From: Billington and Langho Parish Clerk <blparishclerk@outlook.com>
Sent: 11 July 2021 07:09
To: Planning
Subject: 3/2021/0437

Following consultation with the members of the parish council regarding 3/2021/0437 67 Hillcrest Road, Langho BB6 8EN. The parish council would like to object with the following issues raised :-

PROPOSED SIDE

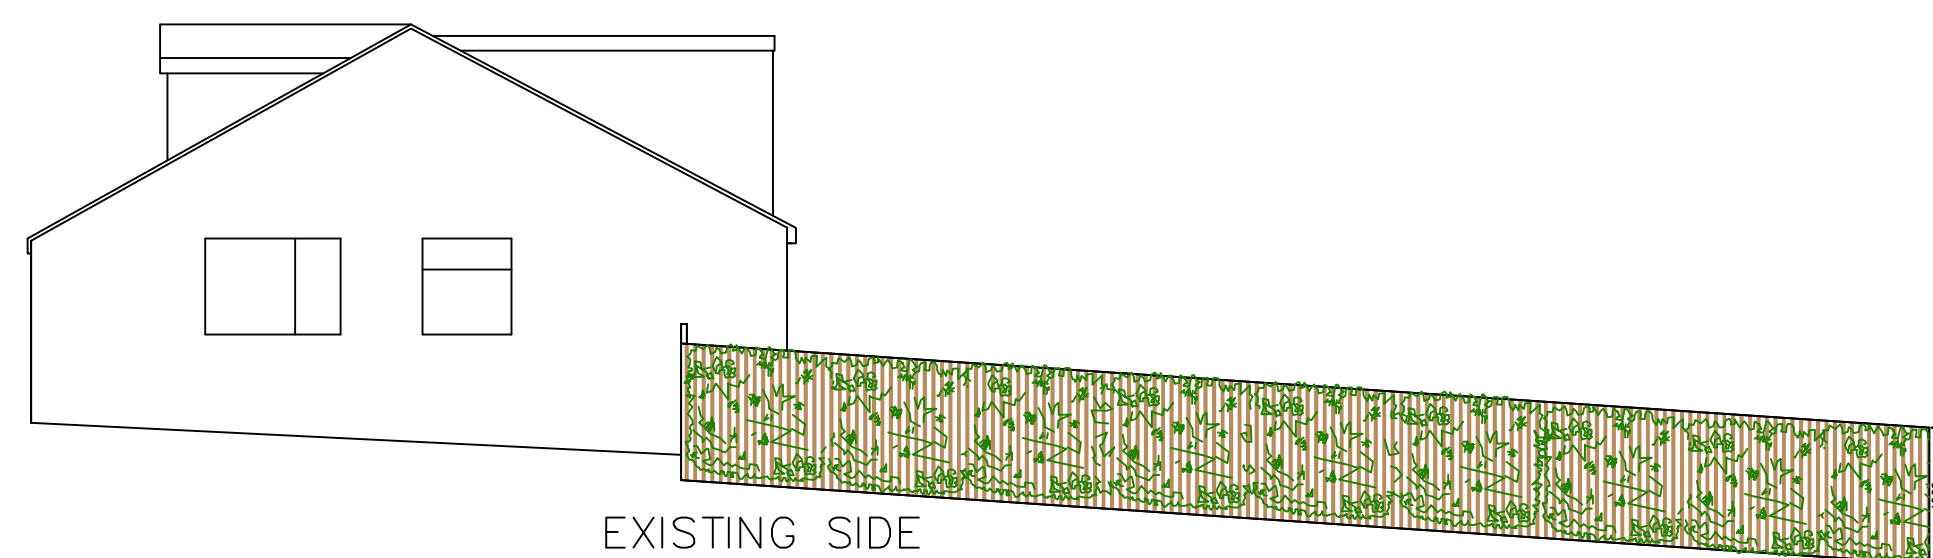
1. The Hillcrest estate is 'open plan', with few, if any fences at the frontages. This , despite the 'added hedge' will be incongruous with every other house on the estate.
2. Concerns were raised how many years the laurel hedge would take to conceal the fence that does look out of place compared to neighbouring properties.
